DRB Minutes, Agenda Items 6 & 7  
June 30, 2021

CITY OF ALBUQUERQUE

DESIGN REVIEW BOARD

Agenda Item 6  
Project Number PR-2020-004595  
Applications:  
SD-2021-00111 - Preliminary Plat  
VA-2021-00216- Sidewalk Waiver

PRELIMINARY PLAT OF  
**ALBUQUERQUE RANCH ESTATES, UNIT II**  
 WITHIN THE ELENA GALLEGOS GRANT  
 PROJECTED SECTION 27, TOWNSHIP 11 NORTH, RANGE 4 EAST, N.M.P.M.  
 CITY OF ALBUQUERQUE  
 BERNALILLO COUNTY, NEW MEXICO  
 MAY 2021

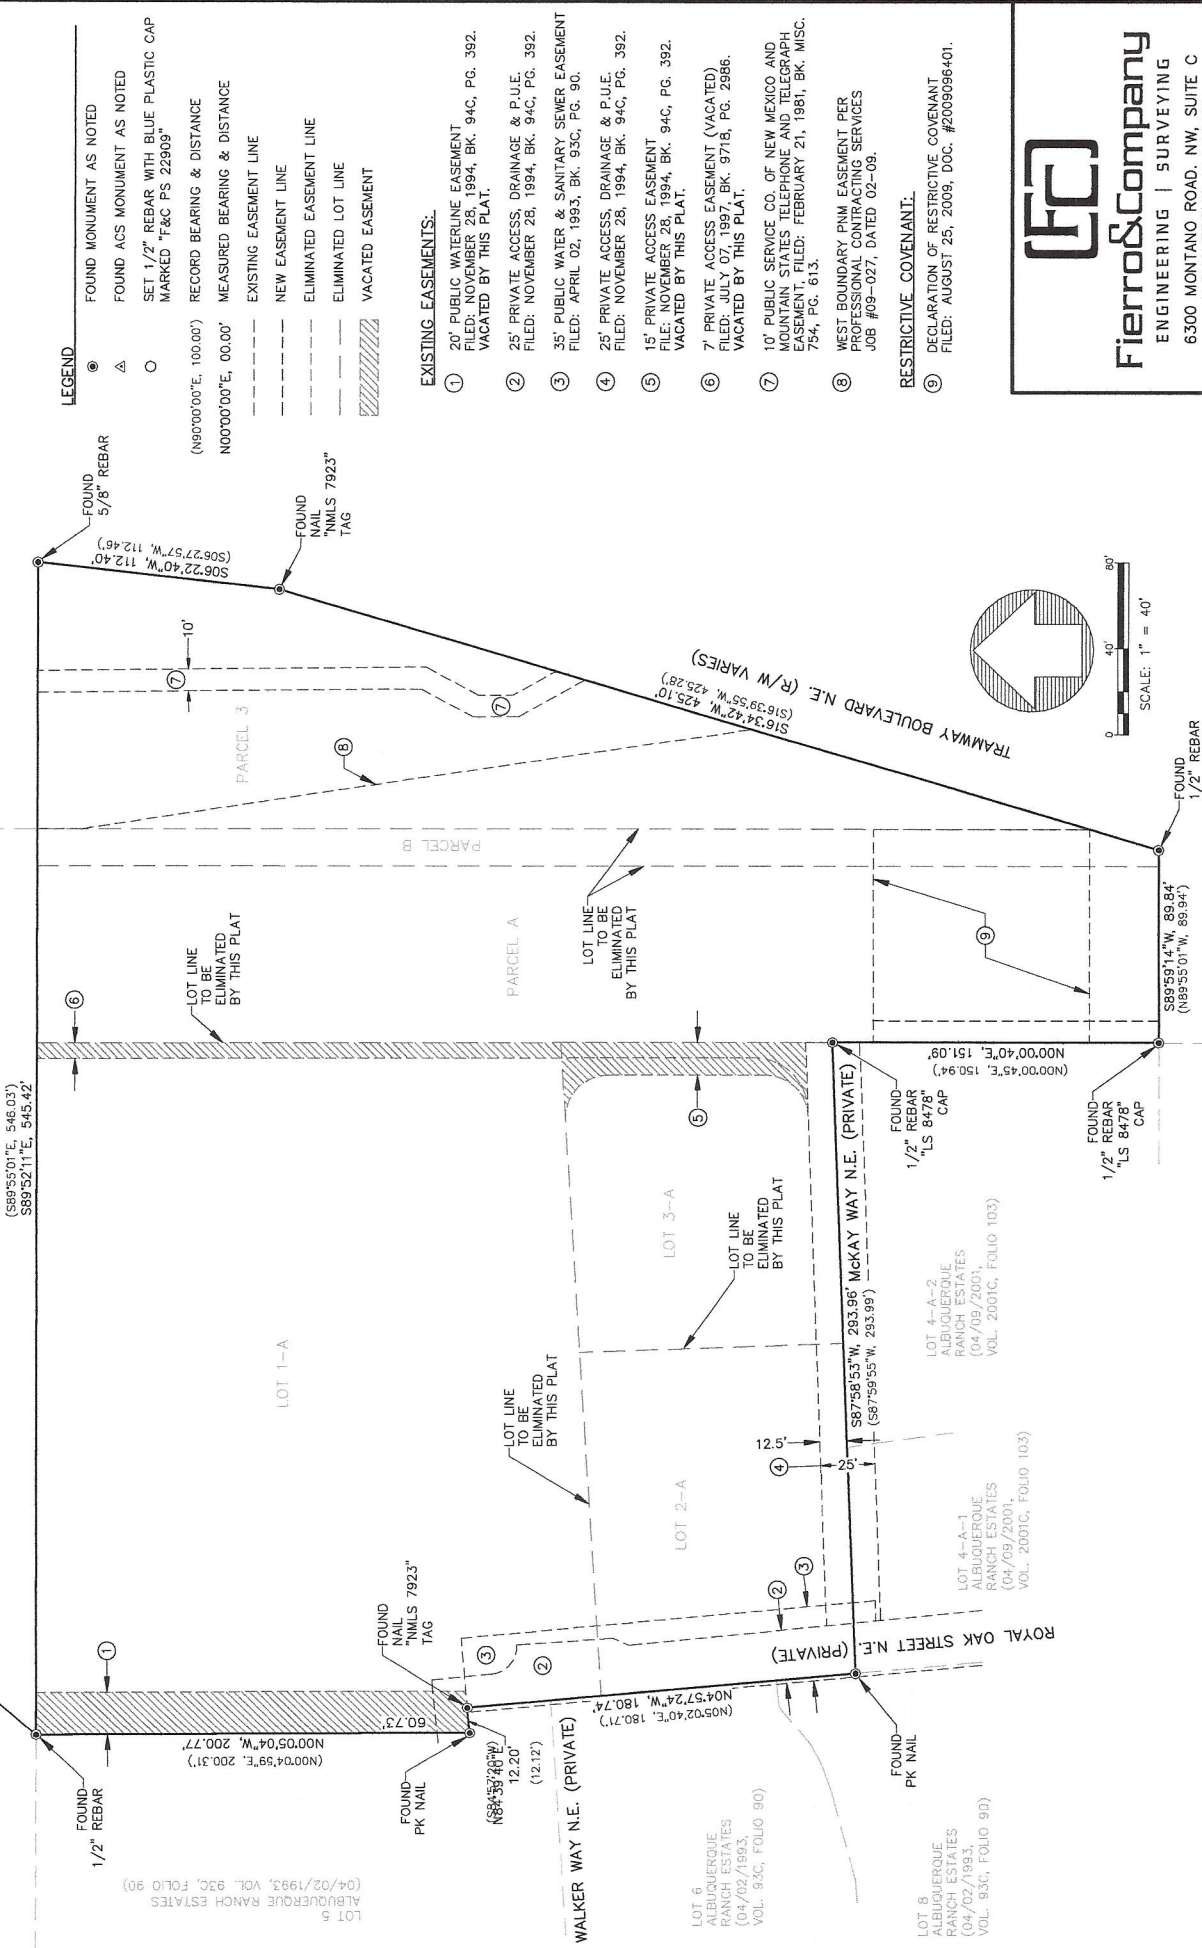
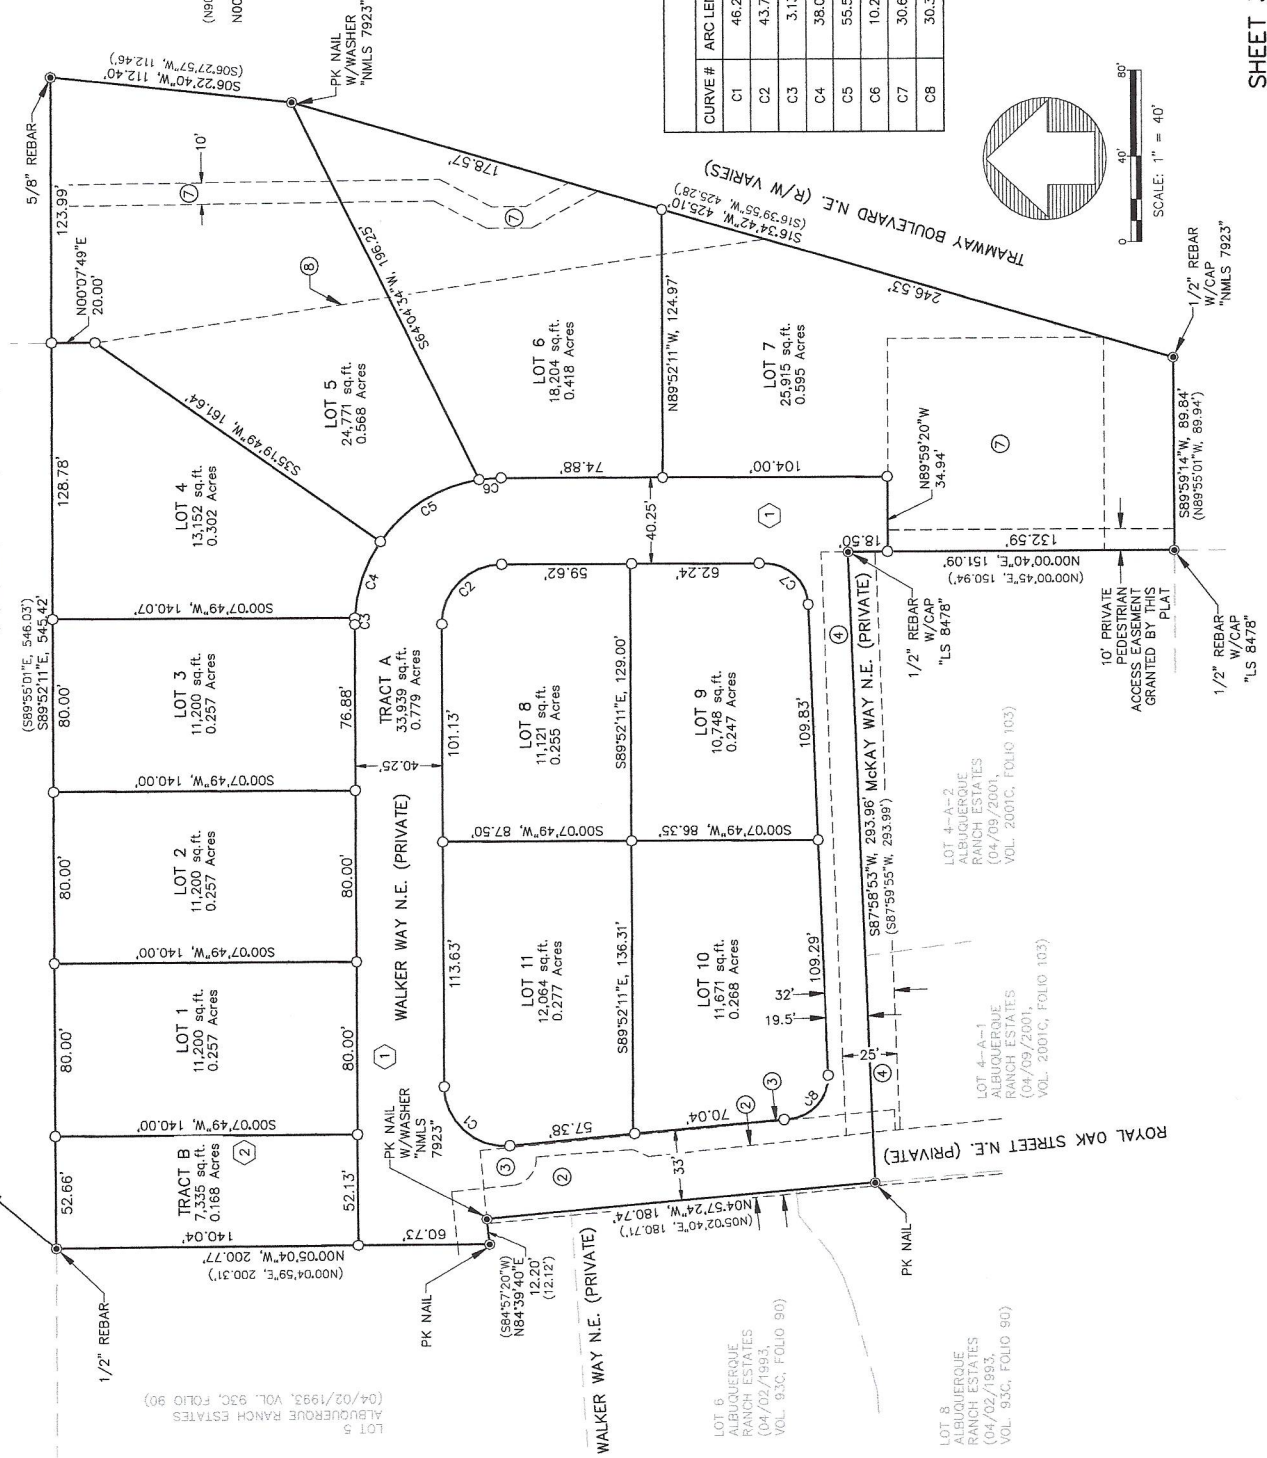
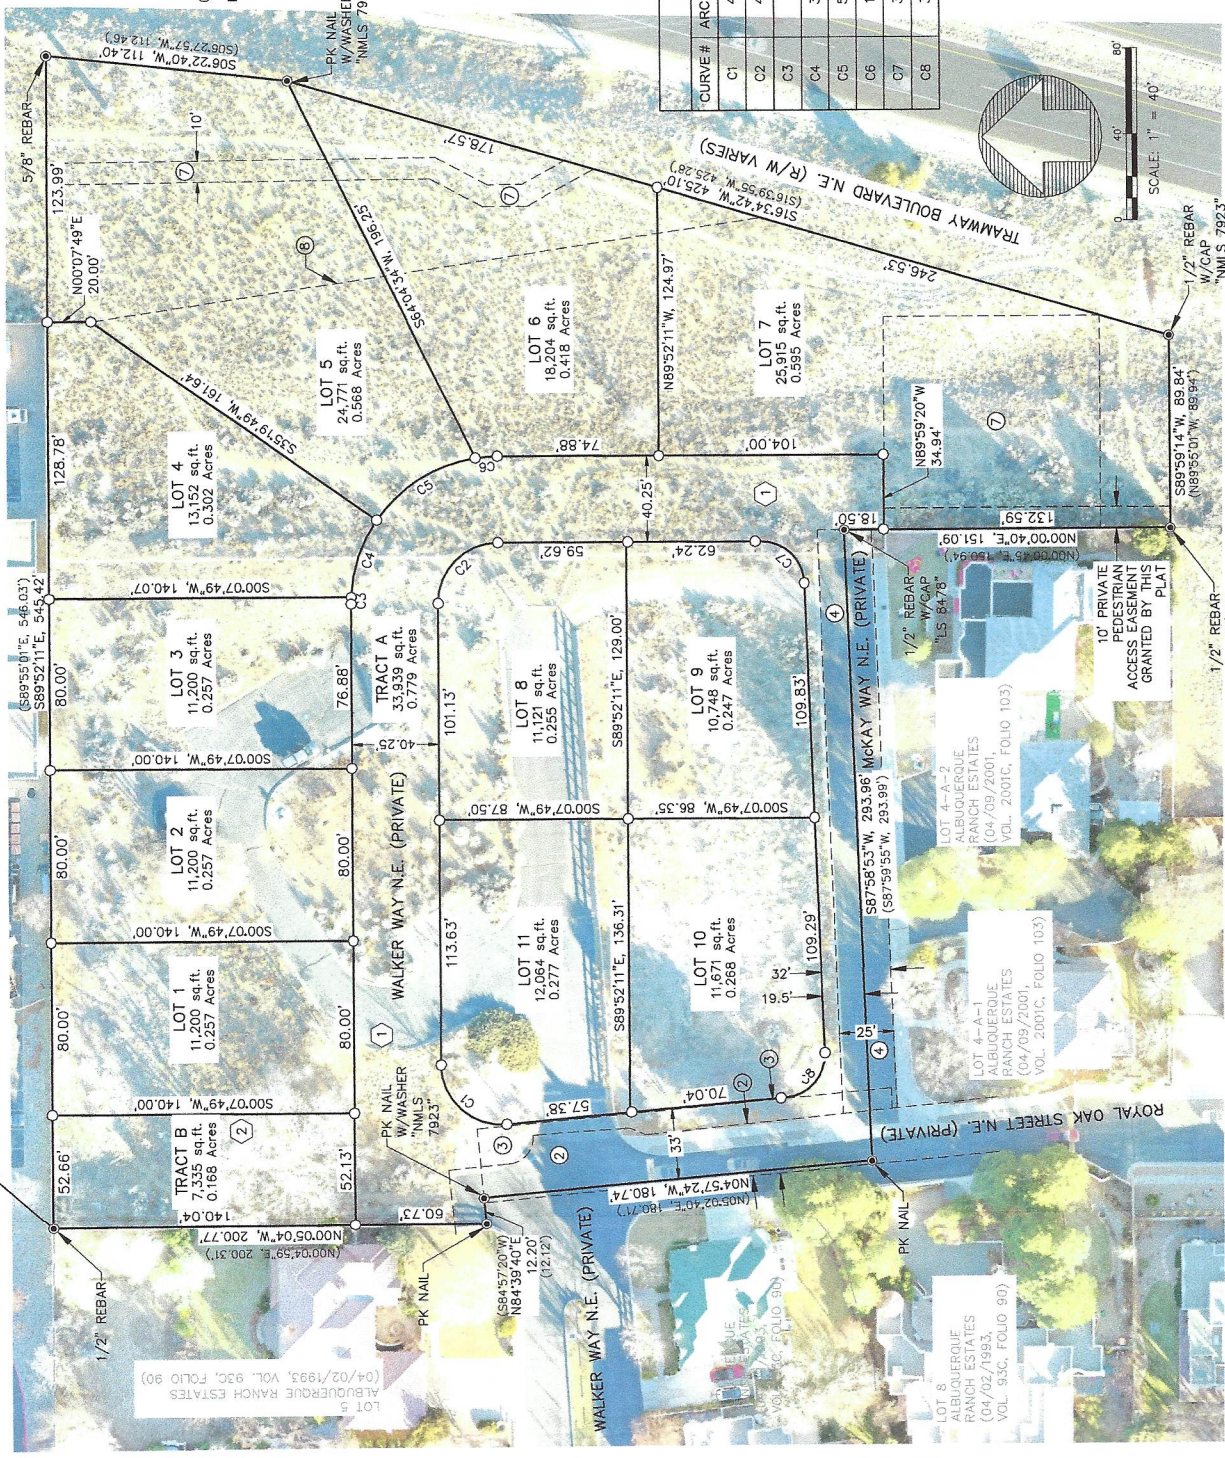
**MS. GARCIA:** So, Madam Chair, Members of the Board, if you'll see, in the middle of the area there, where we have Notes Number 5 and 6, those are the access easements that we are proposing to have removed. So the 5 -- Number -- where Note Number 5 is, that is a 15-foot-wide access easement. It's not clear if it's a vehicular access or a pedestrian access, but, in my mind, given the fact that it's as narrow as it is, we're thinking it's a pedestrian access.

And so Number 6, which is north of that, is a 7-foot access easement that we're hoping to have eliminated with this. That area to the north is just an apartment complex, and so there would be no benefit, no use of having that pedestrian connection to that area because it just -- it just leads to a block wall.

And then to the left of that is, far left of that is, on Number 1, there's where we had the 20-foot-wide water easement that we are hoping to vacate. And our plat shows that the waterlines and sewer lines will run underneath the street. So the streets themselves will have the easements for water and sewer lines.

So if you'll see to the southern part, there is a -- next to Note Number 9, right by the cursor, to the left of that is -- I believe it's a 6-foot wide access easement that will -- that will be granted with this plat to allow the residents within the neighborhood to go out on to Tramway and the ditch bank that's immediately to the south. So there will be a pedestrian connection that will remain within the subdivision. It's just going to be placed in an area that will be useful to the neighborhood.

**MR. BIAZAR:** This is Shahab Biazar. Does it say who are the beneficiary of those easements?

I think it's just for the benefit of Lot 1. If you'll see there, so there's the existing 15-foot access easement. And then it says to the right easement is owned and maintained by the owners of Lot 2A, 3A, 4A, and is private access to Lots 1A, 2A, 3A and 4A, and public utilities to Lots 2A, 3A, and 4A. So it's really just for the benefit of the property owner, the agent -- the property owner and the applicant.
